Planning Act 2008 – Section 88 and the Infrastructure Planning (Examination Procedure) Rules 2010 – Deadline 6: Acoustic Fish Deterrent Report

Application by NNB Generation Company (SZC) Limited for an Order Granting Development Consent for the Sizewell C Project

For Deadline 7 (3rd September) the Examining Authority (ExA) have requested comments on [REP5-123] the Acoustic Fish Deterrent Report submitted by NNBSGenCo (SzC) Ltd at Deadline 5.

Figure 4 – Monthly mean (\pm SDVE) of turbidity (FTU) at the West Gabbard mooring site between 2009 and 2013 (Cefas WG), Sizewell plankton survey in 2014 (BEEMS Sz) and EA monitoring sites between 1992 and 2013 (EA). X-axis represents the month of the year from January to December (1 to 12).

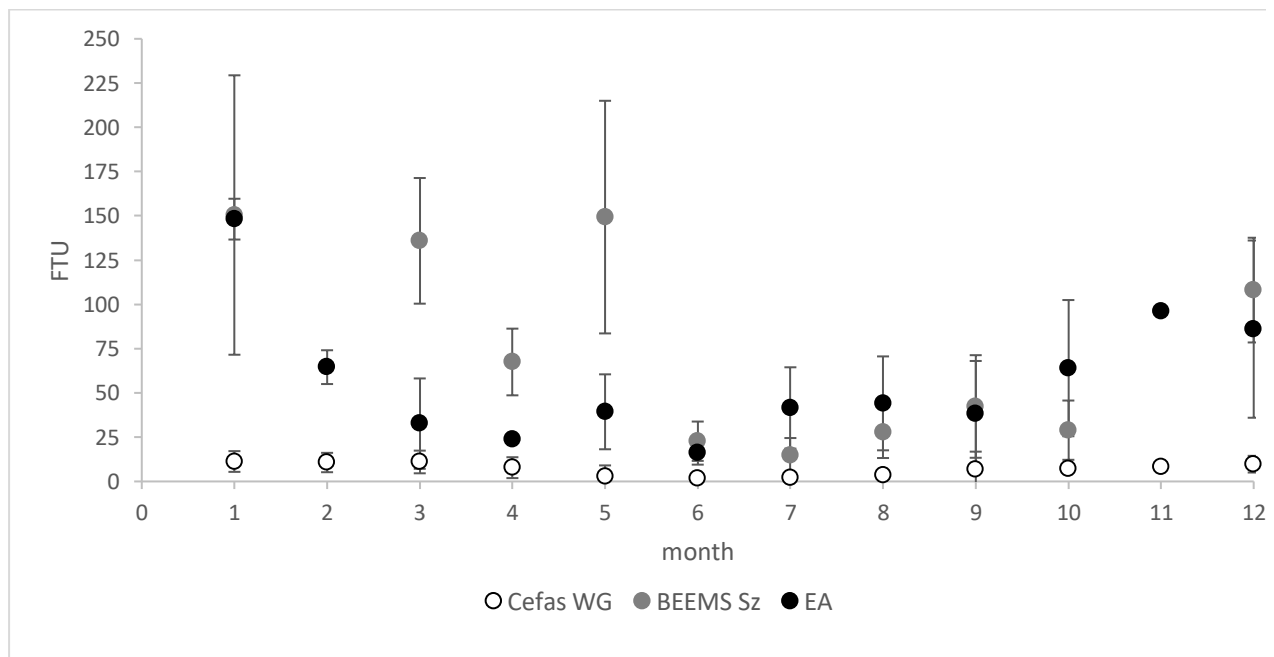
Data provided in the report highlights high turbidity levels, which considered to be a key restriction to safe underwater operation and maintenance of AFD. We consider that the report does not explain that these data are taken from the period of highest turbidity (Nov-Mar) and does not reflect the lower turbidity found in other months of the year.

We accept that winter is the period of highest turbidity. The data used to reinforce the turbidity issue around the SZC area is biased towards sampling at period of expected highest turbidity. We have no evidence that high turbidity persists throughout the year, and in [APP-318] Chapter 22 Marine Ecology Appendix 22A, 2.2.1 (pg 12) it is noted that turbidity is high in several months of the year in the general inshore area, but it is considerably reduced in May

through to August. So sediment loads are highest in winter and decrease as the plankton growing season starts in spring.

Given that within the report no mention is made of turbidity at other times of the year. We consider that evaluation as to the practicalities (including safety) of maintenance operations at these other times of the year should be undertaken.
